Your Ref
TR030006
Our Ref
ADW/ADW/124645.0013
Date
28 October 2021

**Able Marine Energy Park Material Change 2
Alternative construction plans**

Accompanying this letter is a pair of plans showing the potential revised construction sequence, which the Applicant would wish to be an alternative construction sequence. As this would be different to the sequence plans in the material change application this would require an amendment to the amending DCO, namely:

Project: (TR030006) ABLE Marine Energy Park  
 Client: ABLE UK Limited  
 Drawing Title: Indicative Sequence Plan View 1/3

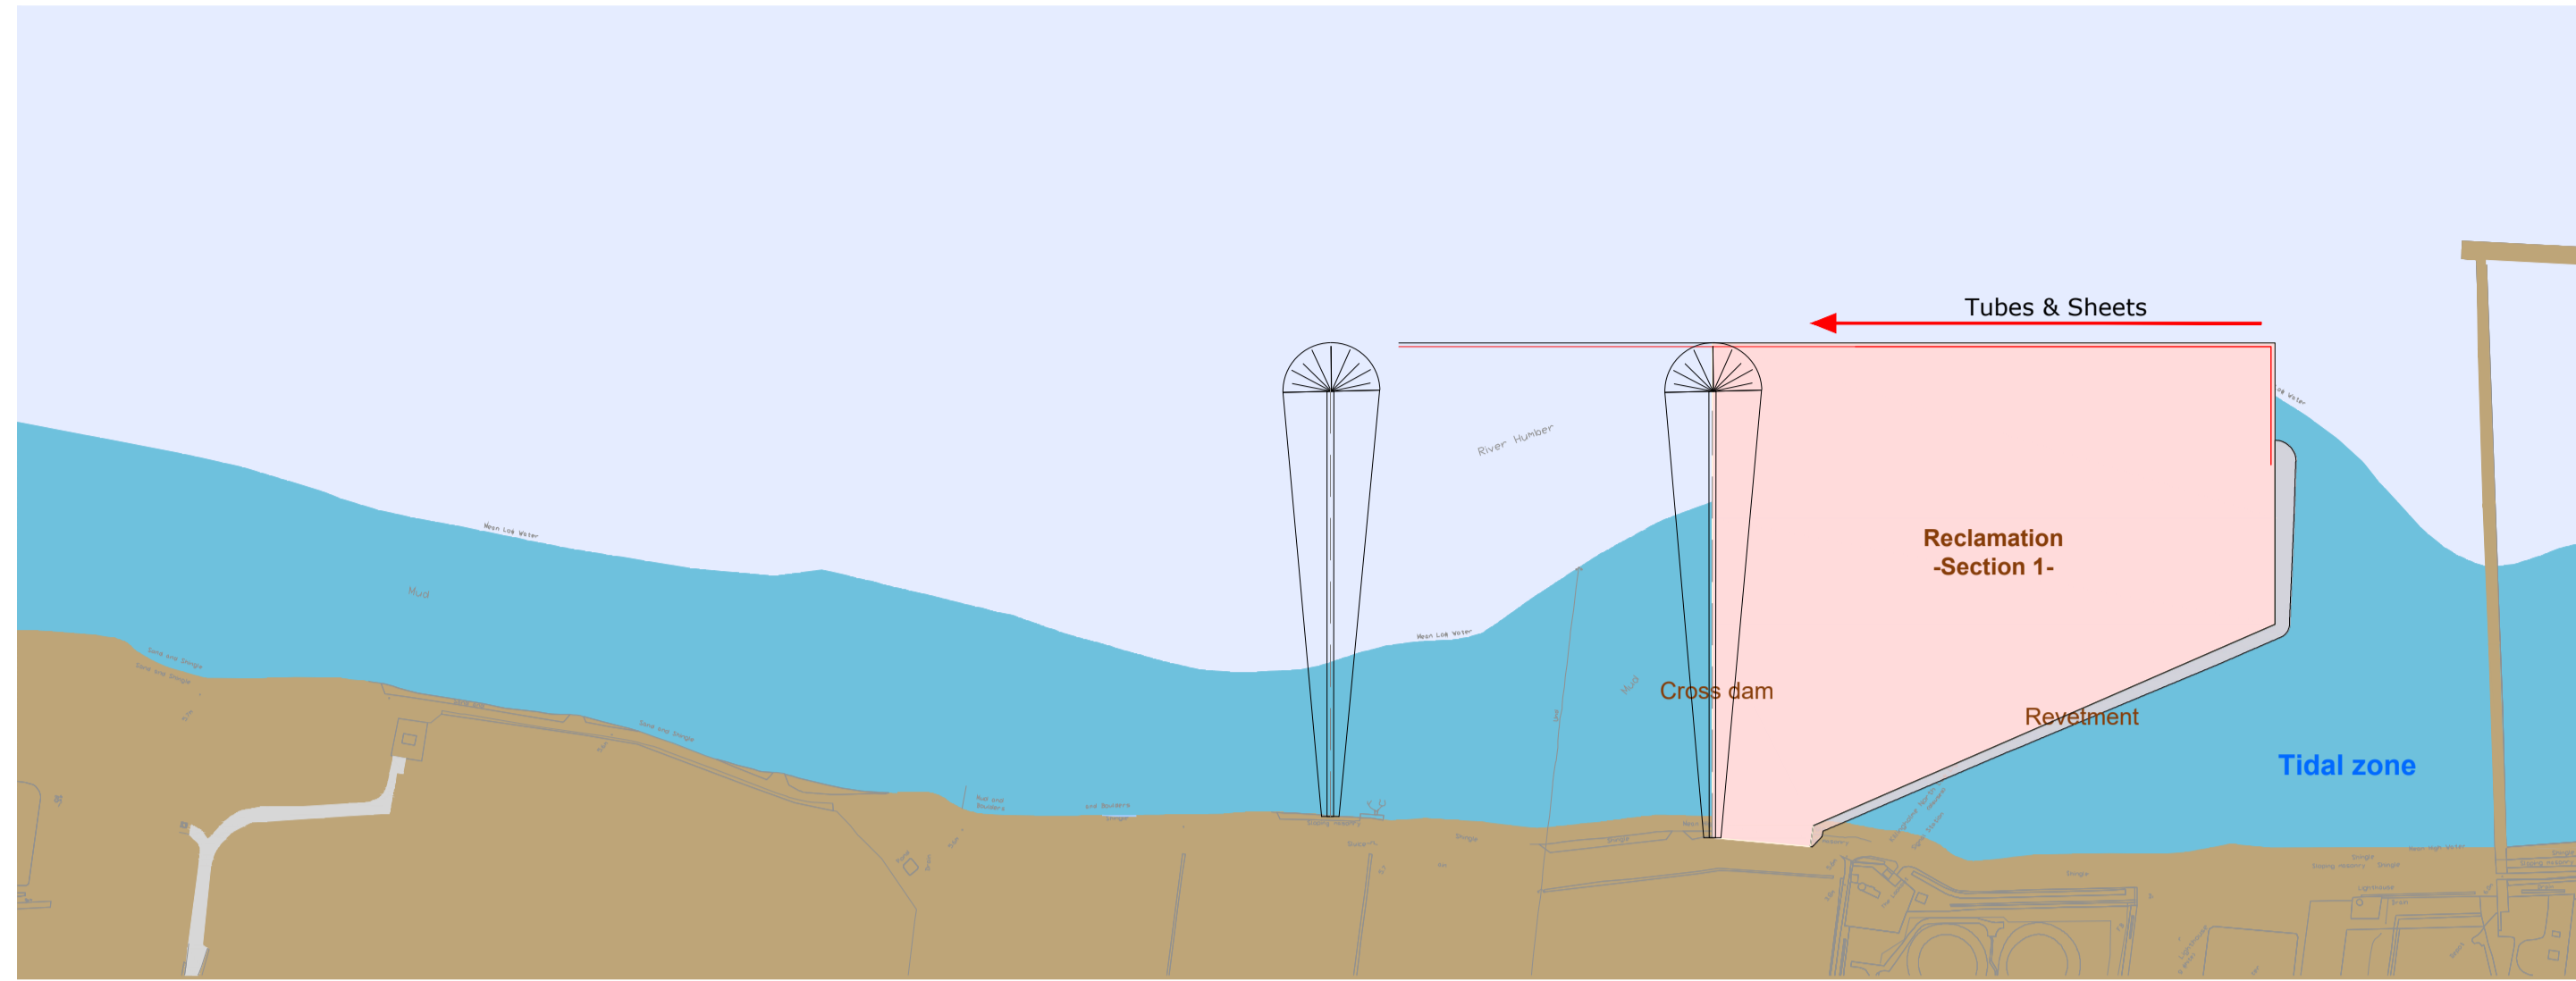
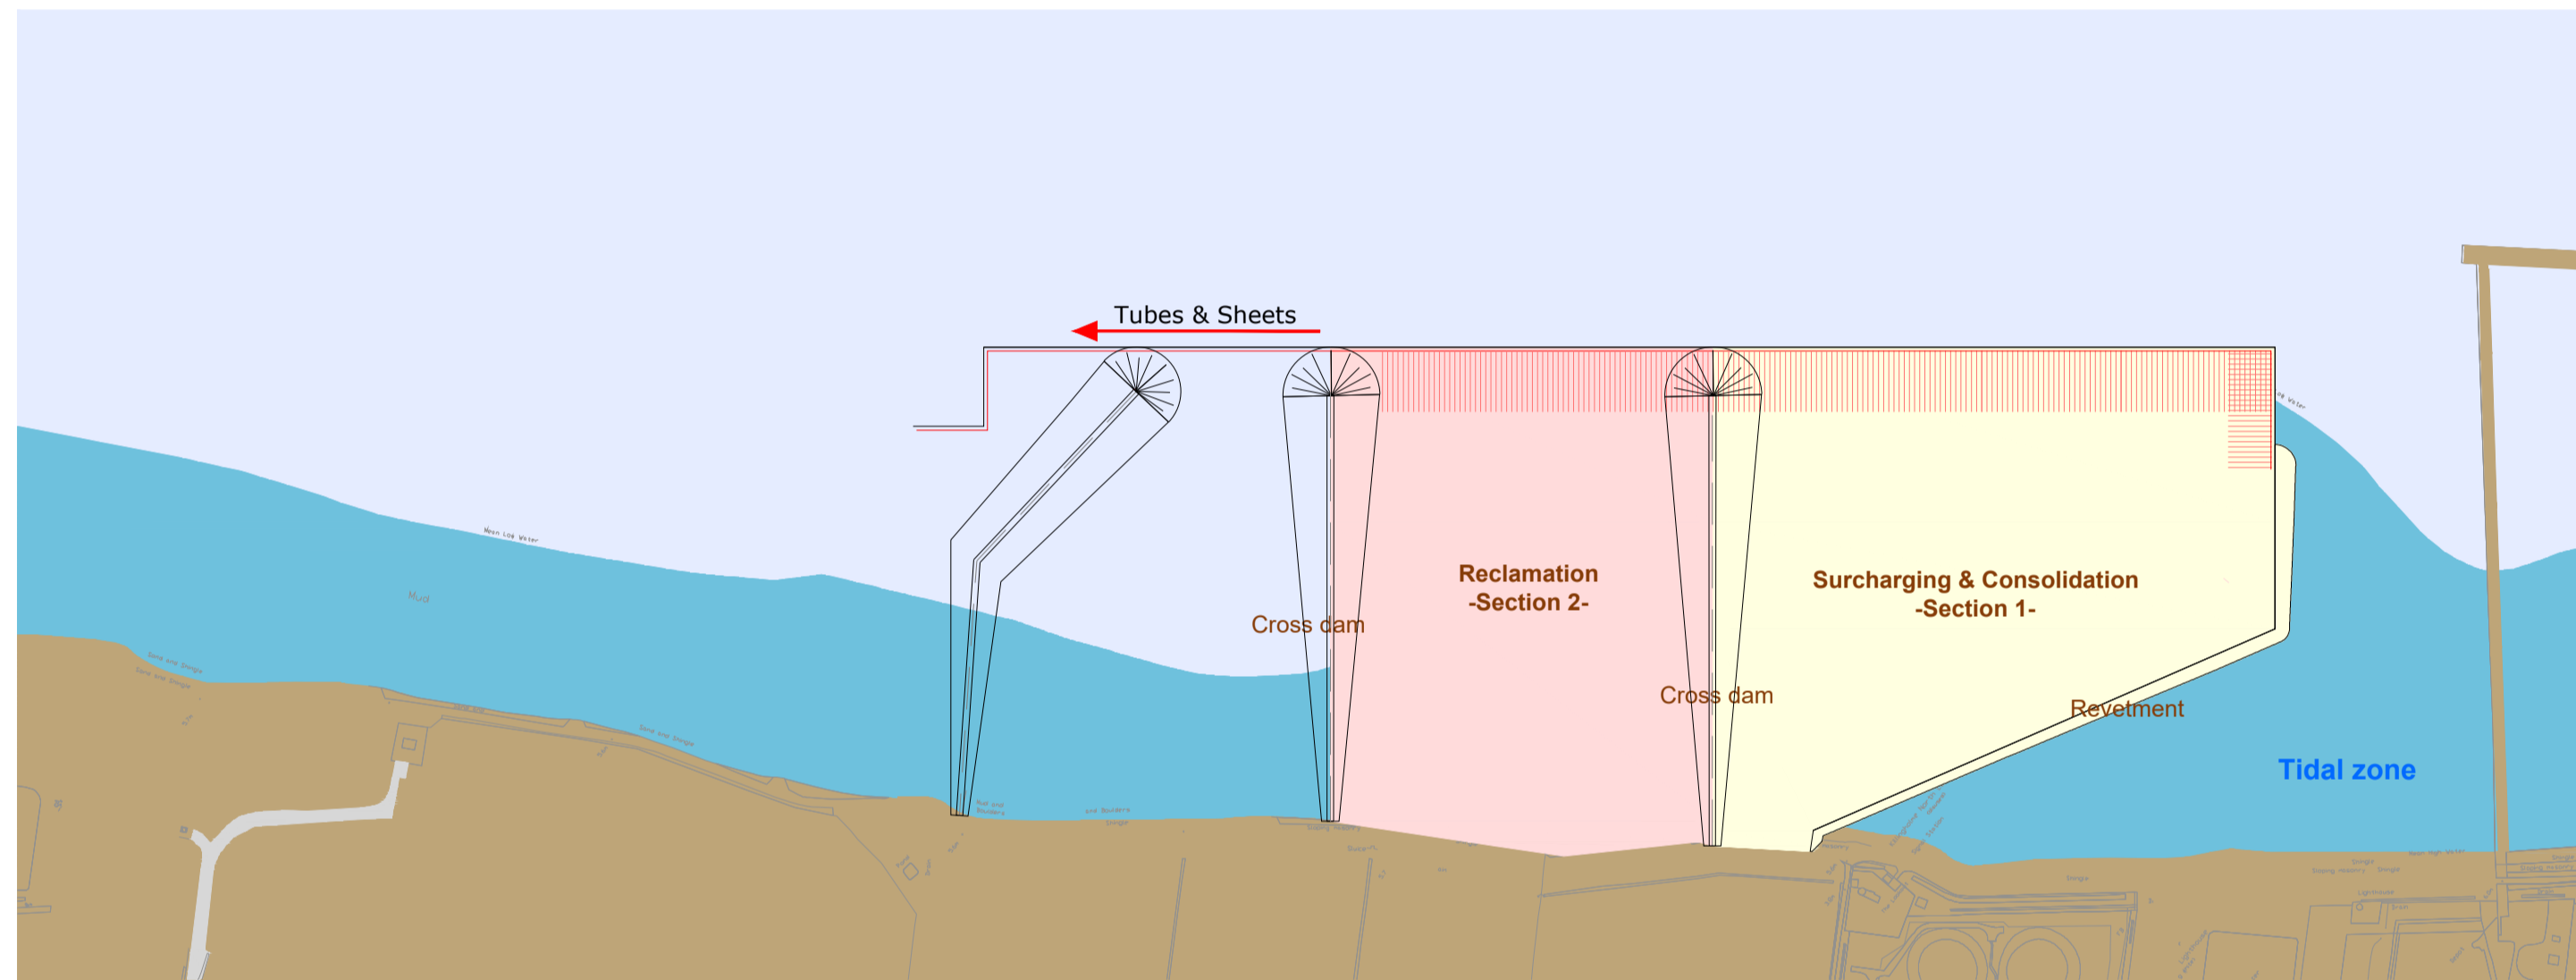
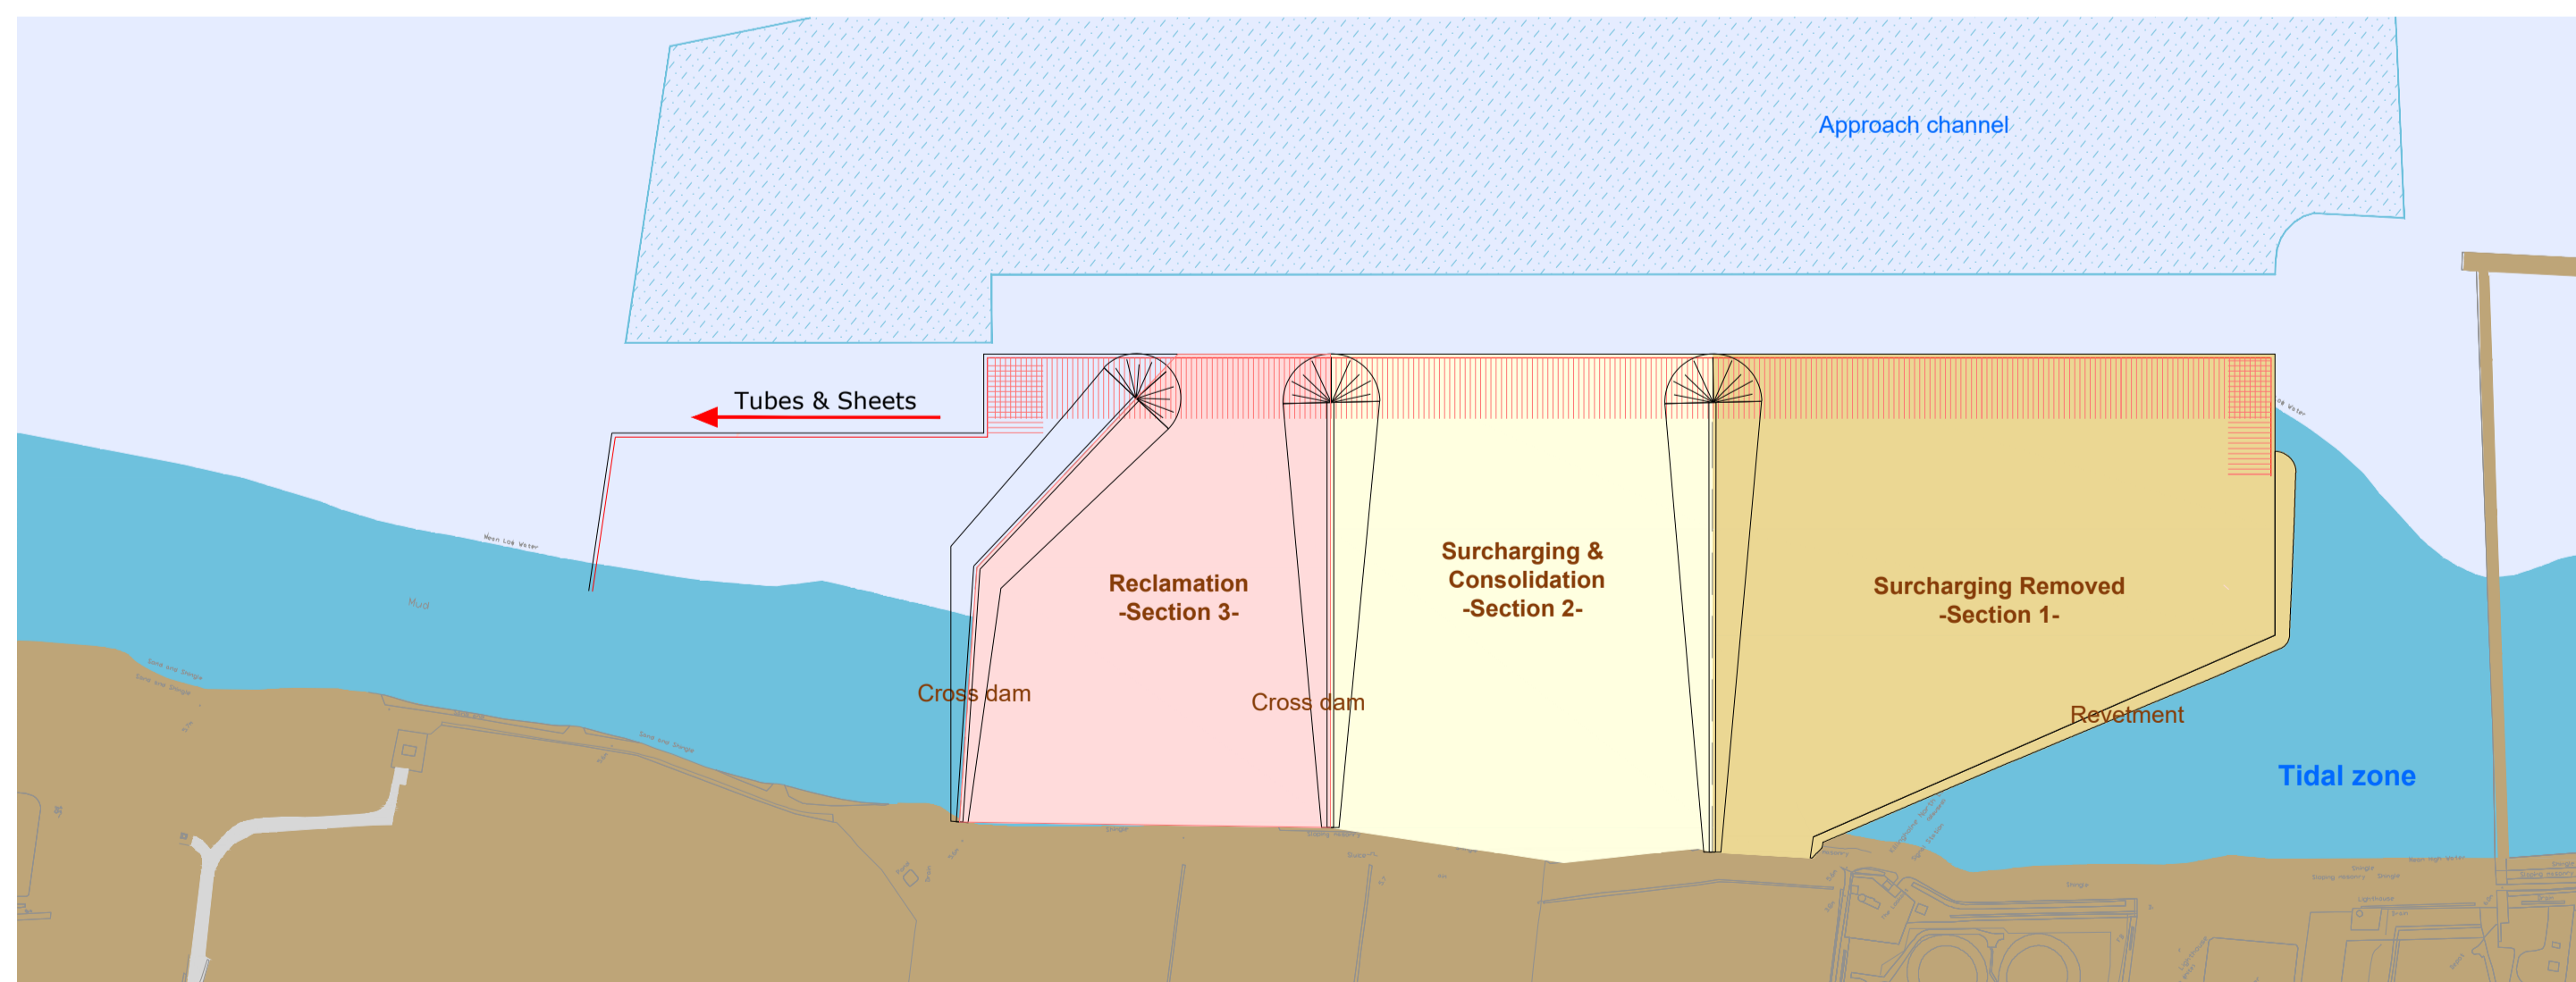
The original construction sequence was to build the quay from north to south; the material change proposes reversing this to build the quay from south to north. A variation on both of these has been proposed, namely building the revetment at the north first, and then building the quay from south to north, starting with a revetment at the south. This would mean that the specialist equipment needed to build the revetments would only need to be mobilised and used for one period at the start rather than being re-mobilised to build the northern revetment later.

- in article 2(5)(o) "AME-036-10009 (Rev C)" becomes "AME-036-10009 (Rev C) or AME-036-10009 (Rev D)" and
